A47 Blofield to North Burlingham Dualling

Scheme Number: TR010040

Volume 9 **9.6 Schedule of Changes to dDCO**

3 August 2021

**HE551490-GTY-EPC-000-DR-CH-30006**

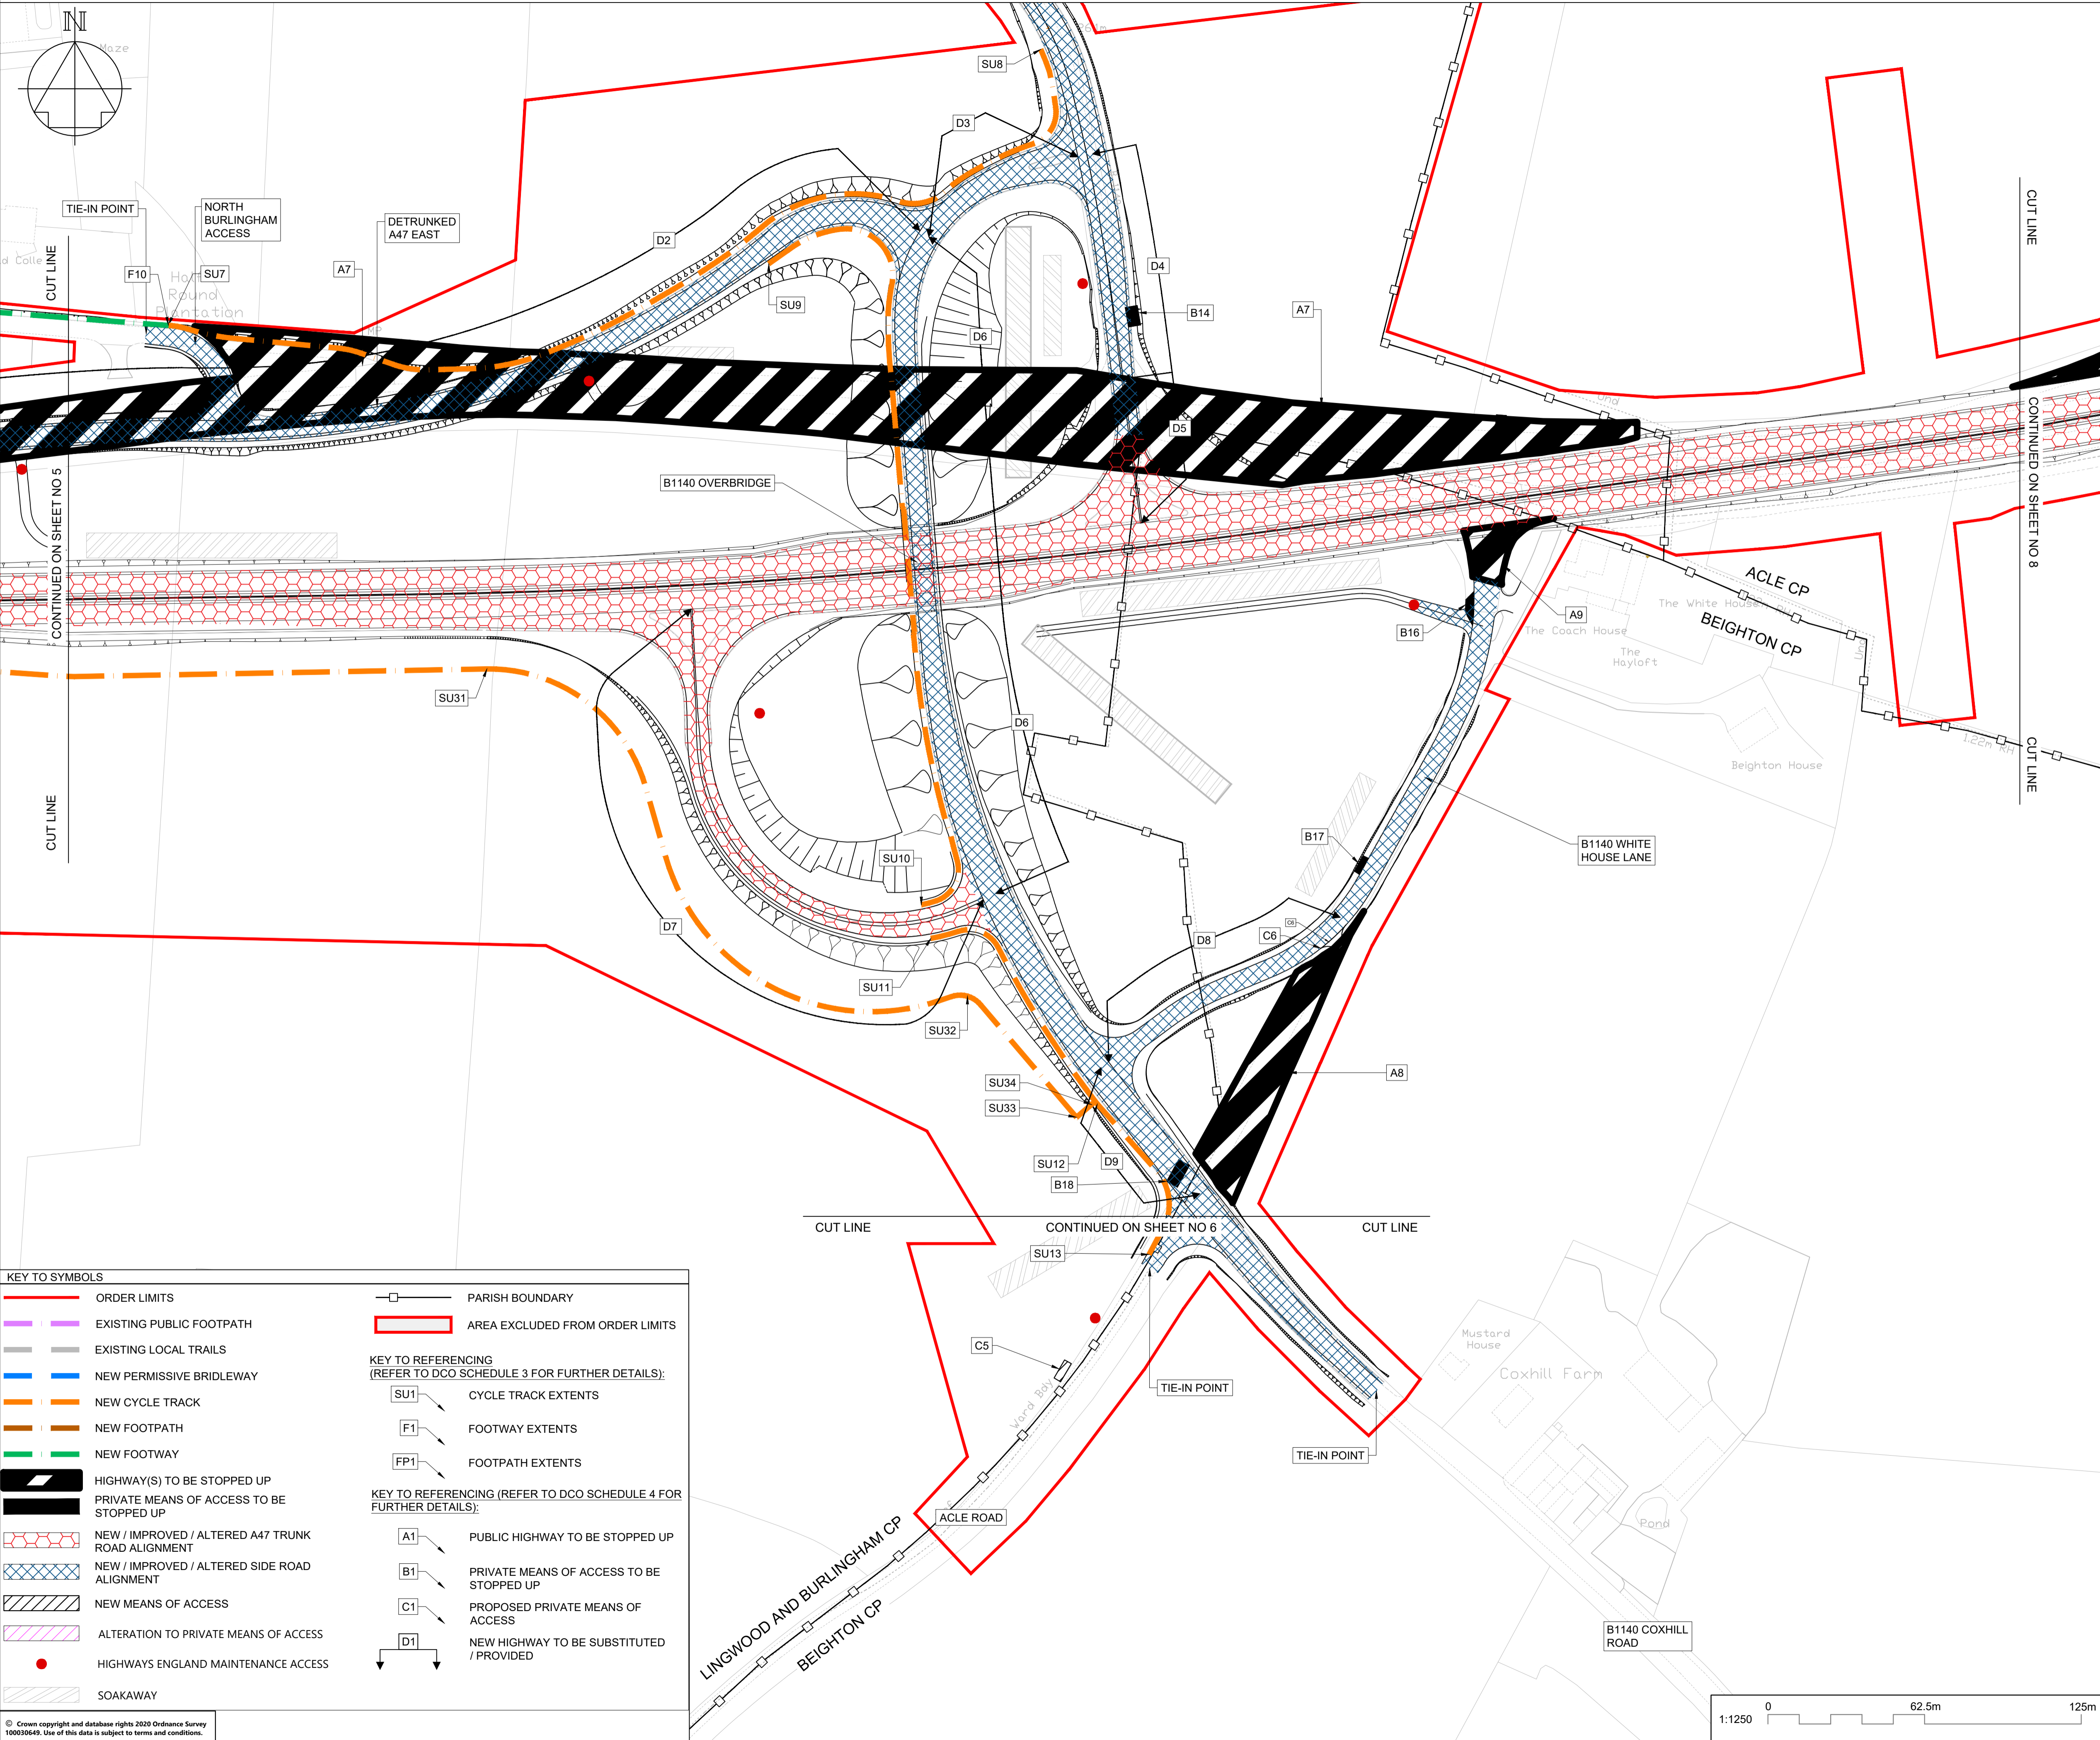
<p>Schedule 3: "Classification of Roads etc"</p> <p>Part 6: "Footpaths, Cycle Tracks, Footways and Bridleways"</p>	<p>Amend the entry relating to cycle track SU7 to SU8 to:</p> <p>(1) After the word "from point SU7," delete the word "at" and add the words "96 metres east of"; and</p>	<p>The description of Cycle Track SU7 to SU8 did not take into account footway FP9 to FP10 which was</p>	N/A	N/A

Article/Schedule	Change	Reason for change	Precedent used	Consequential changes
"The rights of way and access plans – sheet 6"	(2) After the words "a distance of" delete the number "352" and replace it with the number "255"	<p>shown on the rights of way and access plans.</p> <p>Note that Point SU7 is being moved slightly to the west on the revised right of way and access plans submitted at Deadline 3 so that the cycle track is coterminous with Main Road.</p>
